OXFORDSHIRE COUNTY COUNCIL'S RESPONSE TO CONSULTATION ON THE FOLLOWING DEVELOPMENT PROPOSAL

Application no: 16/00219/REM-2

Proposal: Reserved matters to 14/01737/OUT - Appearance, landscaping, layout and scale of 45 no. dwellings

Location: The Paddocks The Hale Chesterton

### Inset Box 1 - LAP

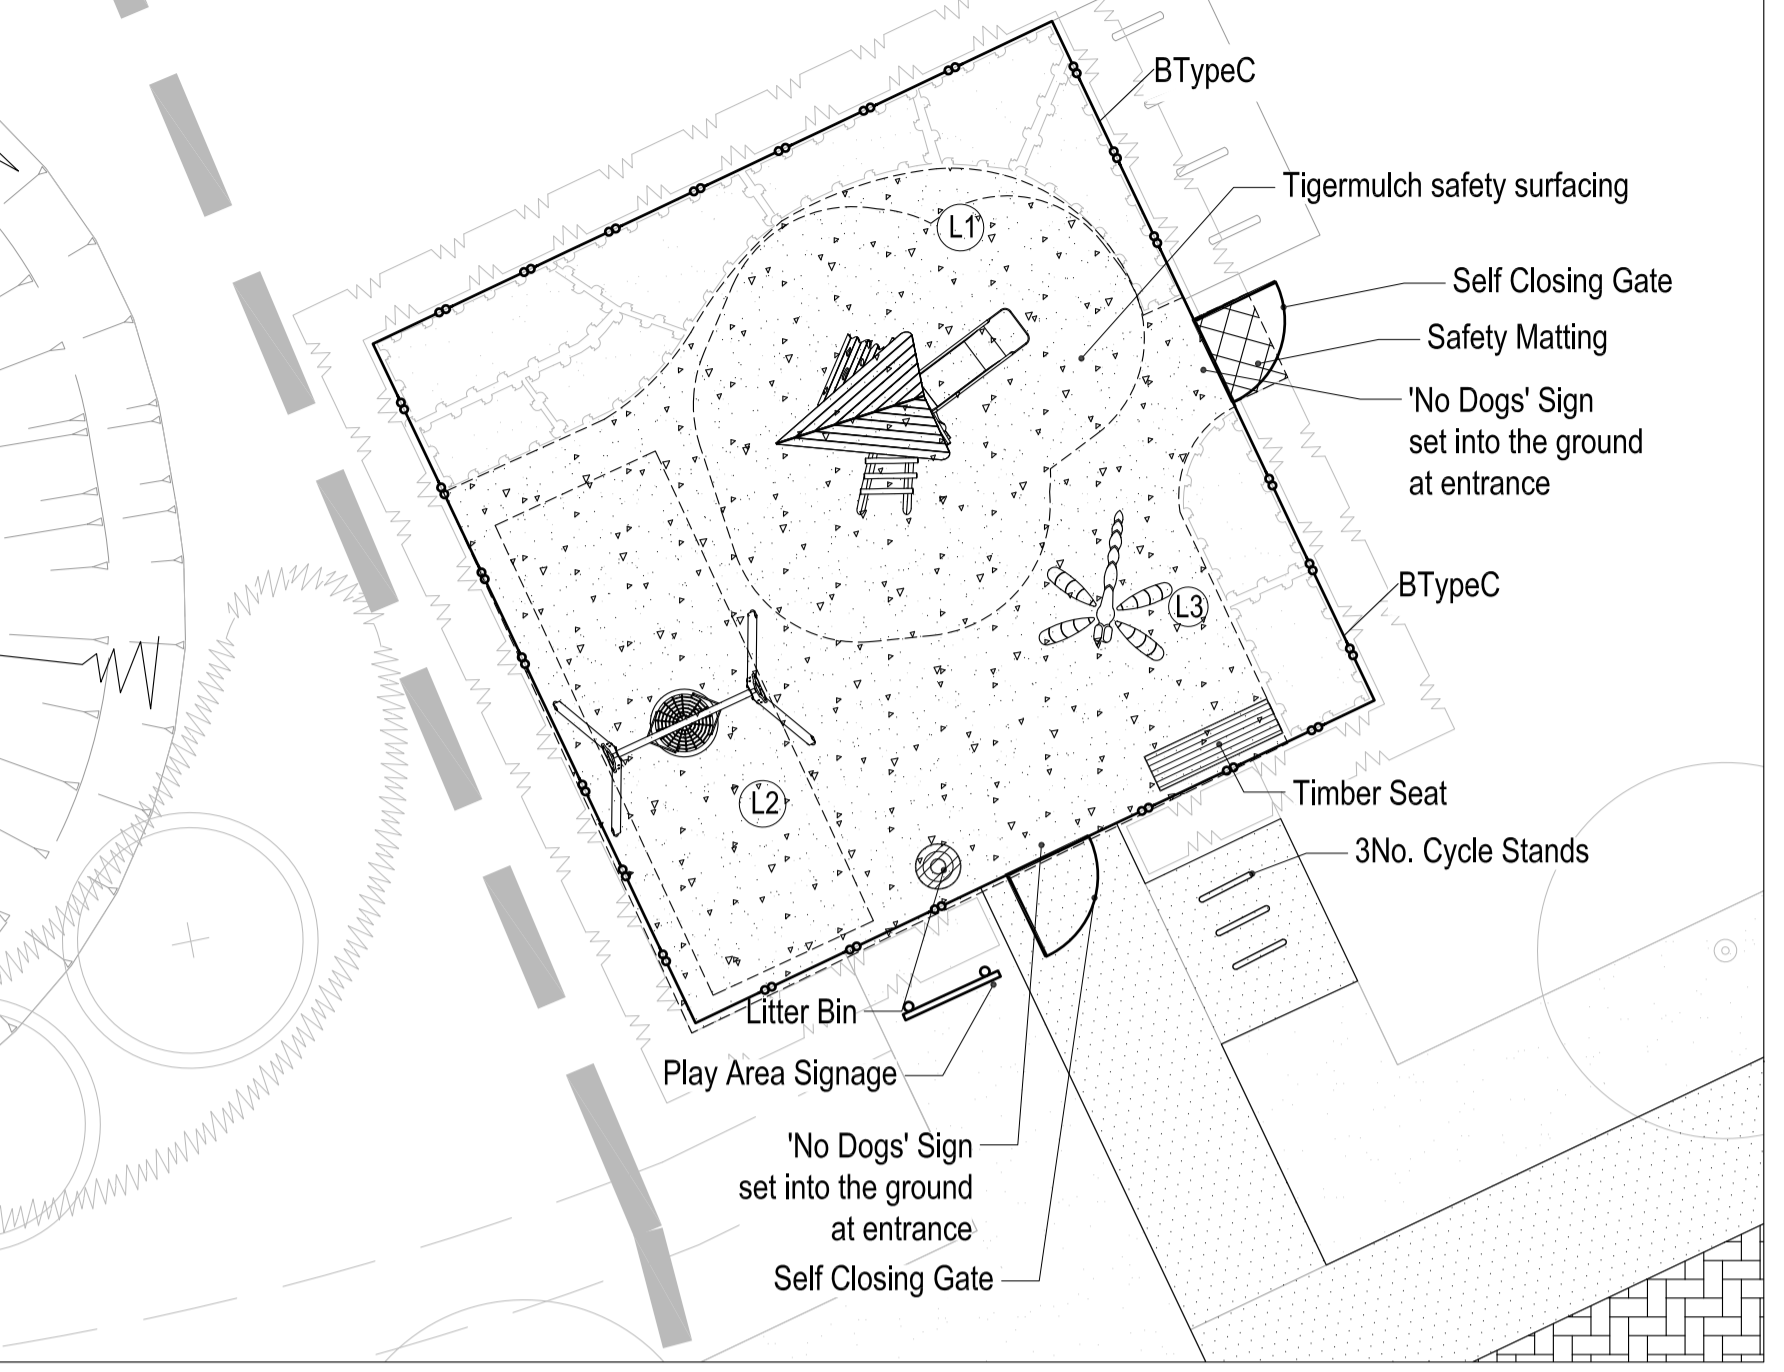
There is now a small rectangular area immediately to the south of the LAP. It is assumed that this is visitor / public cycle parking for the LAP in response to OCCs previous comments. If this is the case then the provision of cycle parking for the LAP is acceptable. This should be labelled on future plans.
